from
**Southern
Water**

Your ref
BN/84/20/PL

Proposal: Application for variation of conditions imposed on planning reference BN/43/16/PL relating to Conditions 2 (Approved Plans), 8 (Access/Maintenance of Watercourse or Culvert) and 18 (Access and Associated Off-Site Highway Works).

Site: BN/84/20/PL: - Land at Angels Nursery, Yapton Road, Barnham, PO22 0AY.

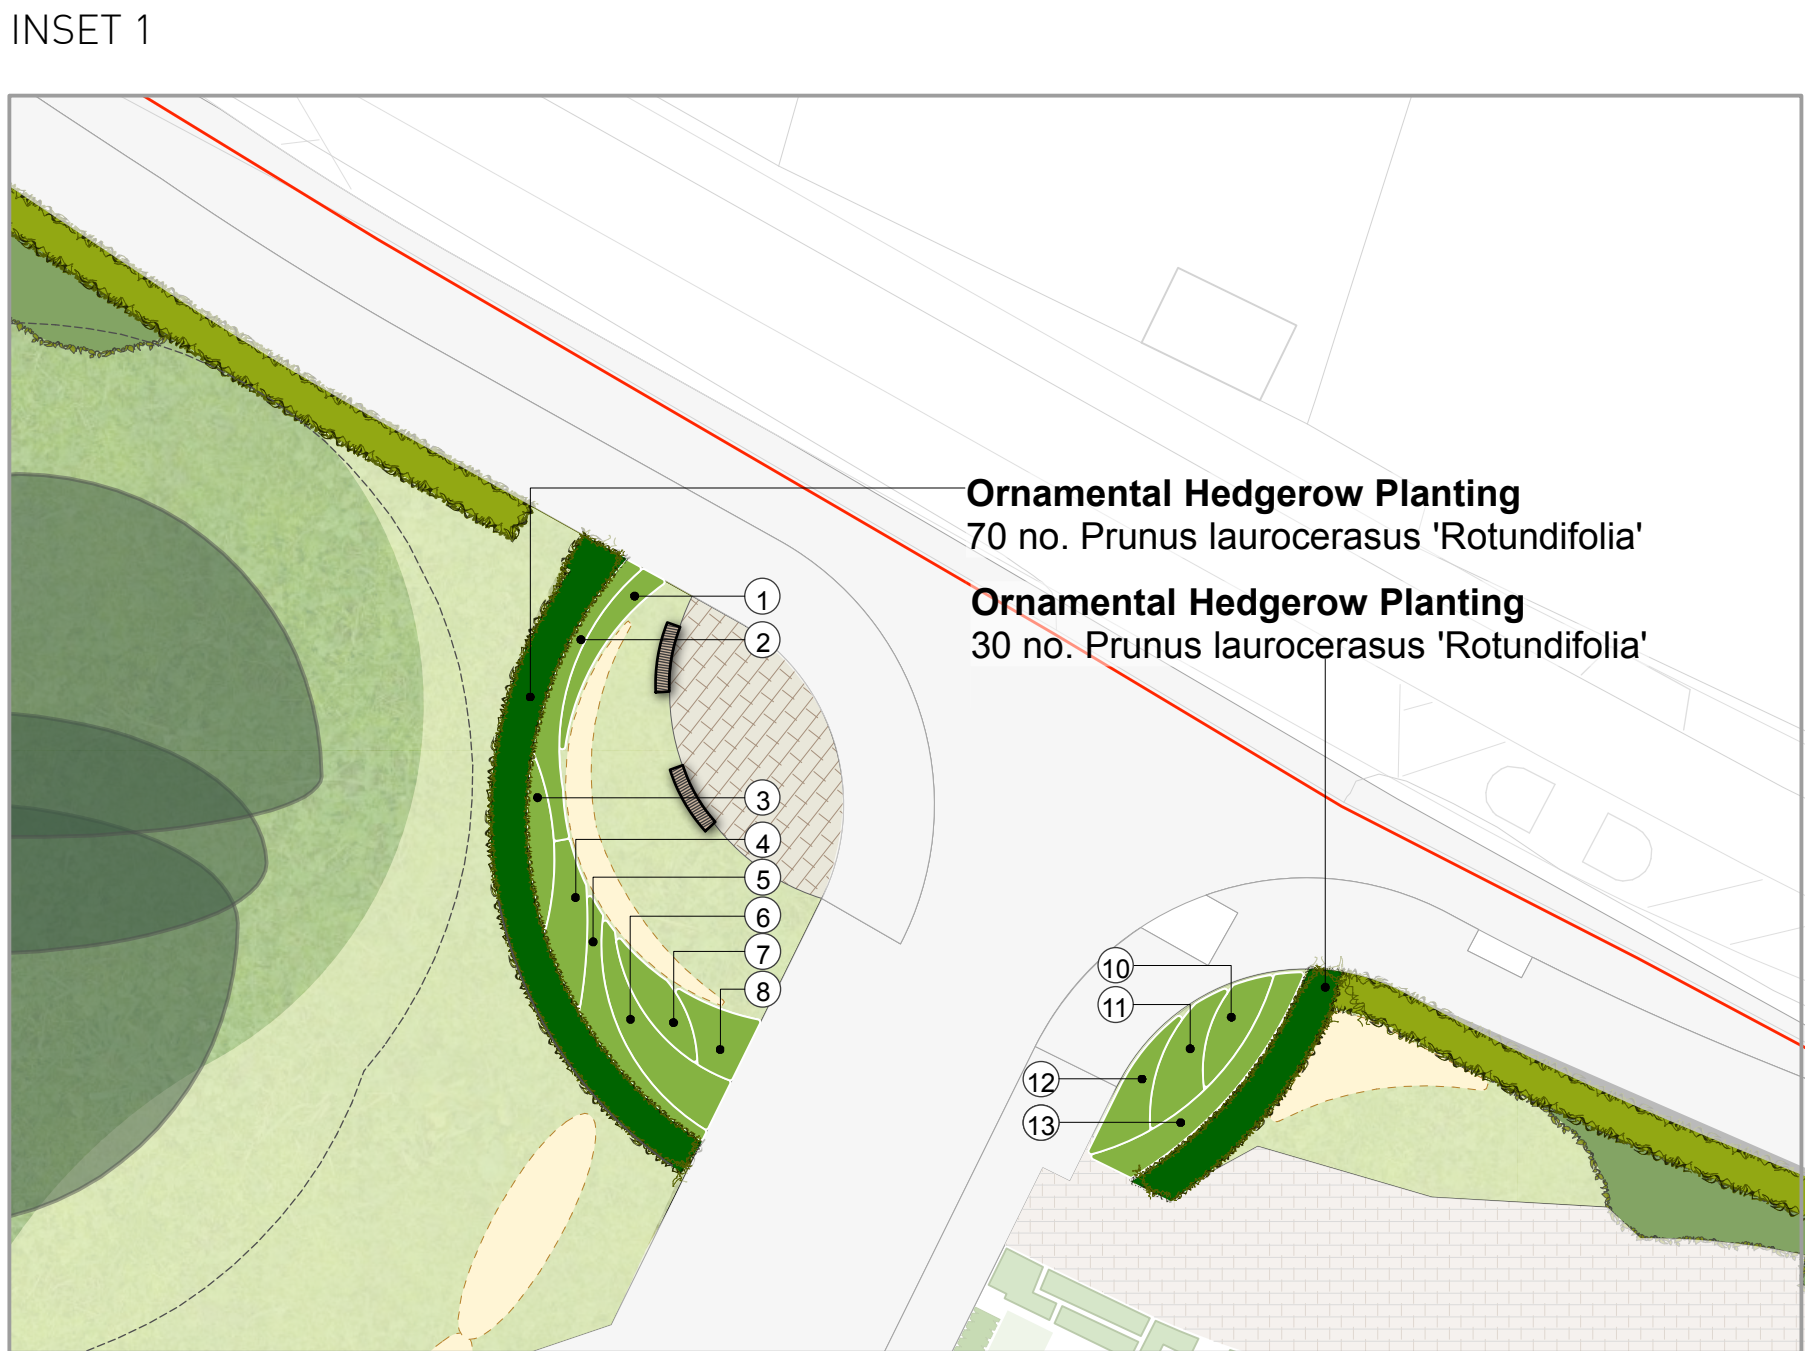
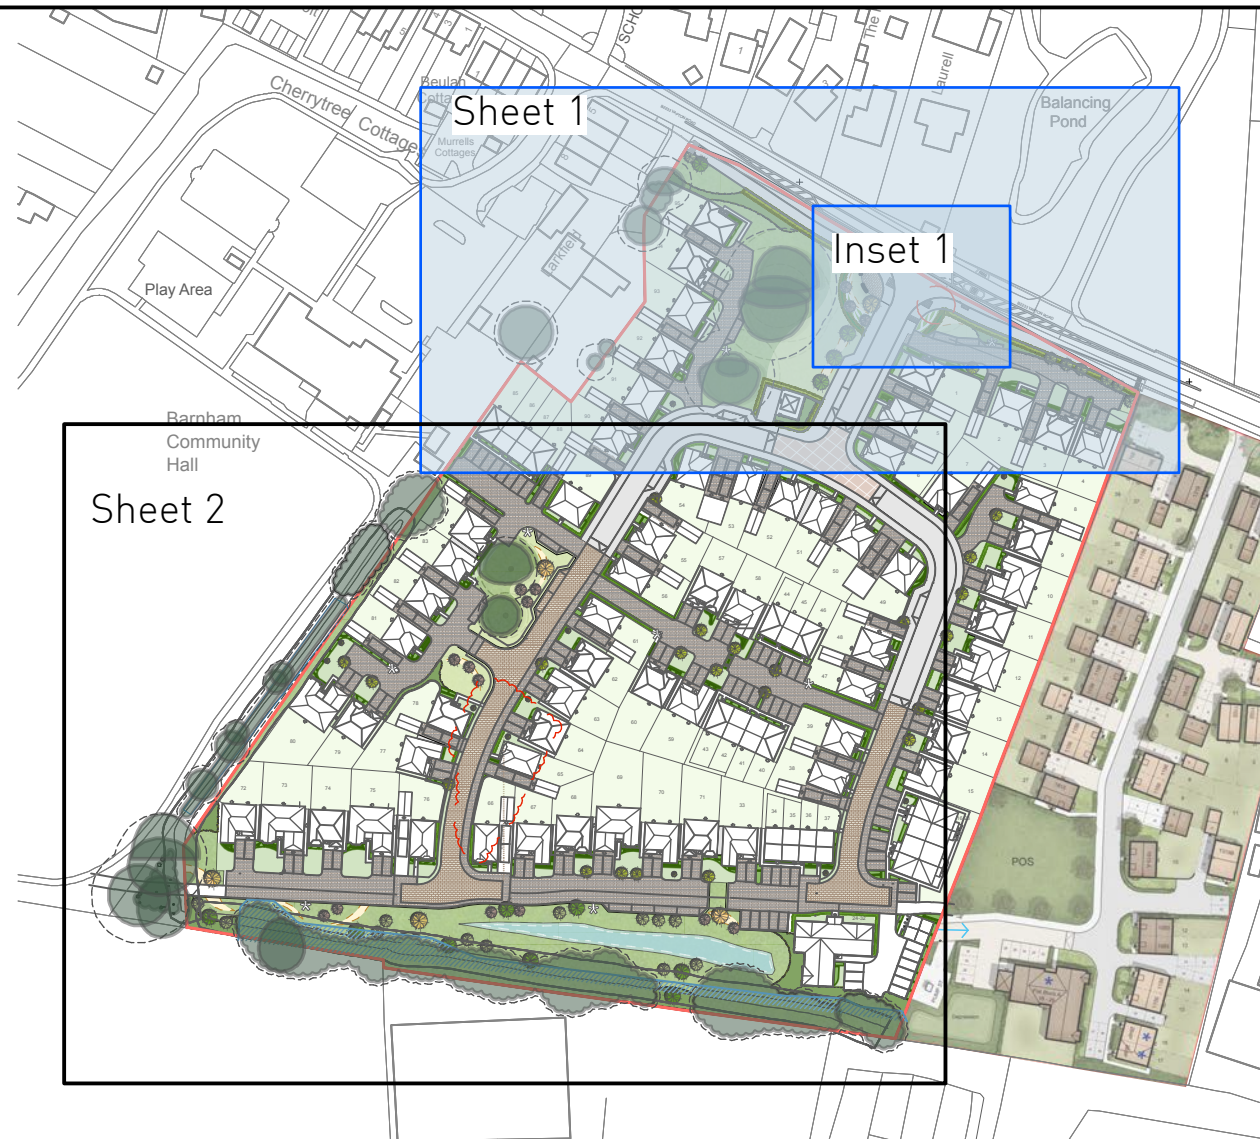
Southern Water has no objections to variation of conditions 02, 08 and 18. The submitted plans shows proposed tree planting within standoff distance from public drainage apparatus.

We have restrictions on the proposed tree planting adjacent to Southern Water sewers, rising mains or water mains and any such proposed assets in the vicinity of existing planting. Reference should be made to Southern Water's publication "A Guide to Tree Planting near water Mains and Sewers" (southernwater.co.uk/media/1642/ds-tree-planting-guide.pdf) and the Sewerage Sector Guidance (water.org.uk/sewerage-sector-guidance-approved-documents/) with regards to any landscaping proposals and our restrictions and maintenance of tree planting adjacent to sewers, rising mains and water mains.
